RE: Application 2018/91661 Land at Walkley Terrace and Brunswick Street, Heckmondwike

Sustrans have the following comments to make. These do not supersede our comments made in January 2018 but should be seen as additional. Please note that Railway Paths Ltd owners of the adjacent land will be writing to you separately.

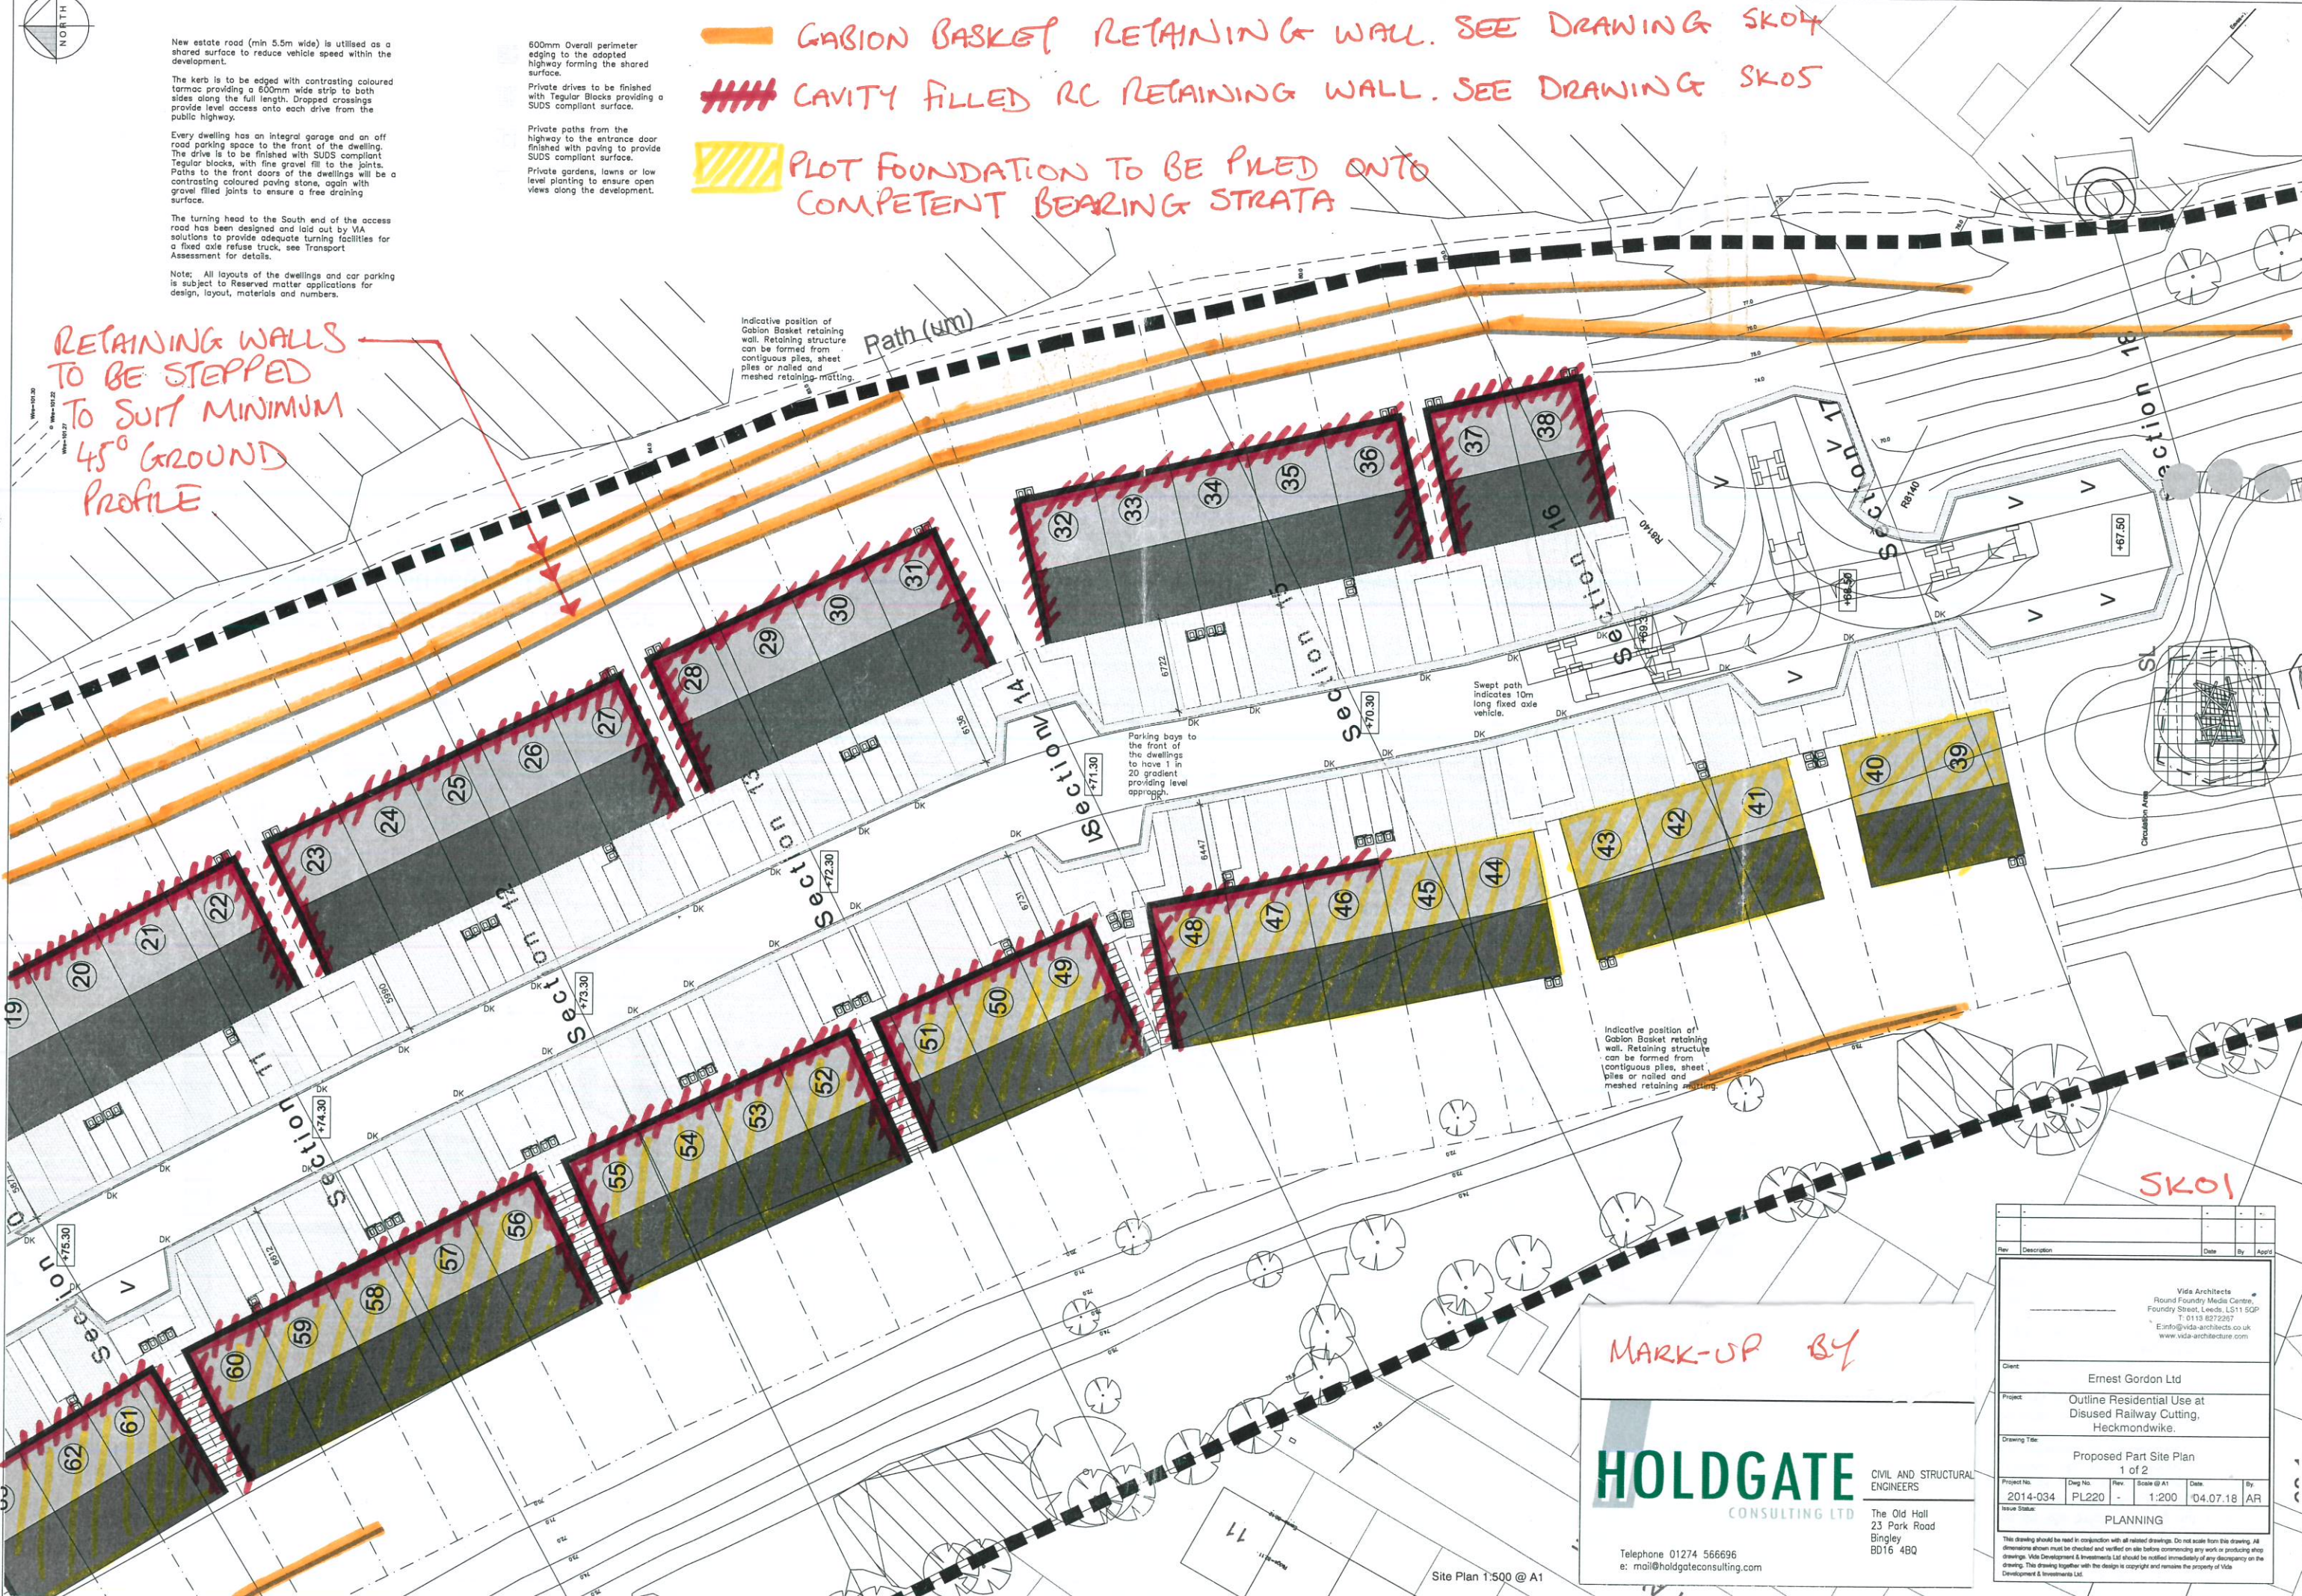
- Flood risk section (para 2.5) refers to surface water flood risk, ponding upstream of Brunswick Street; and water flowing through the site from NW to SE during storms. Raising site levels would therefore 'dam' water on this land. The land and structures 'upstream' of Brunswick Street (including the bridge carrying Brunswick Street) are owned by our sister charity Railway Paths Limited and this land is earmarked for linking the existing Spen Ringway to Spen Greenway at Walkley Lane. We cannot agree to any proposal that would potentially damage or degrade our land or structures.

- Affordable Housing Units 18
- Dwellings 56
- Total Dwellings 74

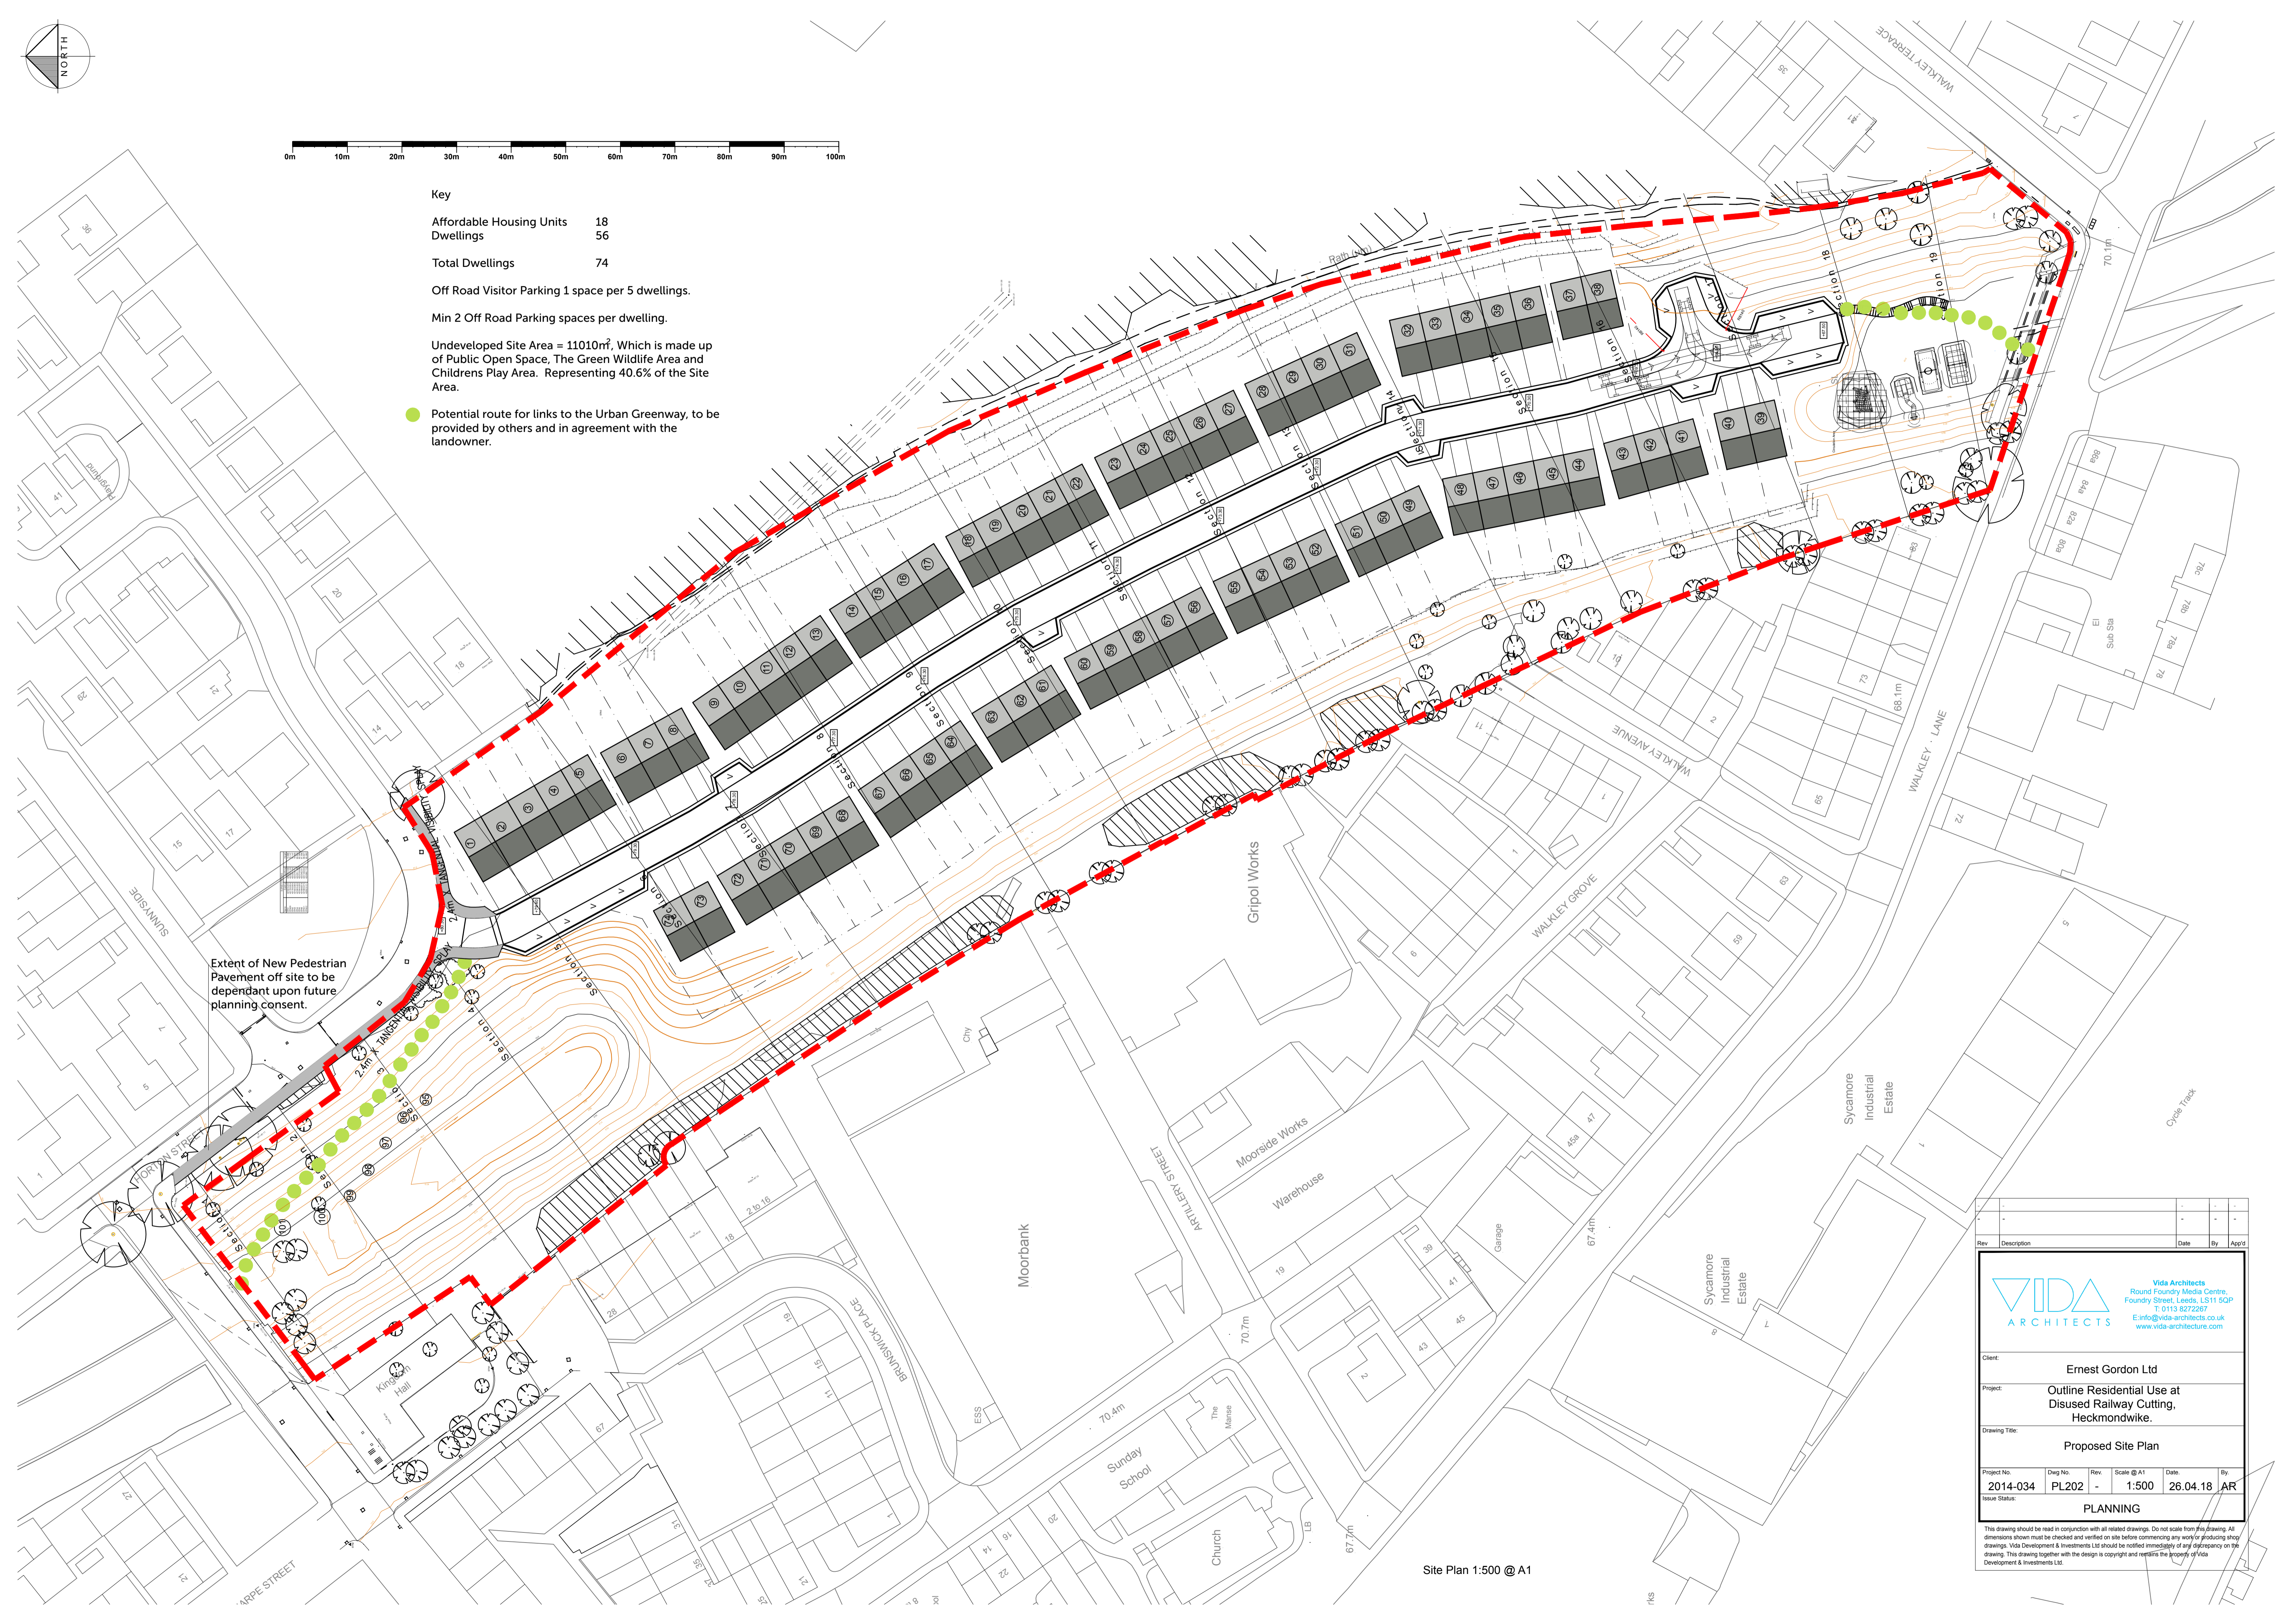
- The cycle route that was discussed previously running along the southern edge of the development is not shown or mentioned anywhere.
- The drawings show a green dotted line labelled 'potential route for links to Urban Greenways, to be provided by others...'. These just link to either end of the main road through the housing estate and looks very steep at the west end and link to steps at the east. This is not acceptable.
- The cross sections do indicate a level area along the southern boundary, where we thought the path was to go, though this now appears to be part of gardens.
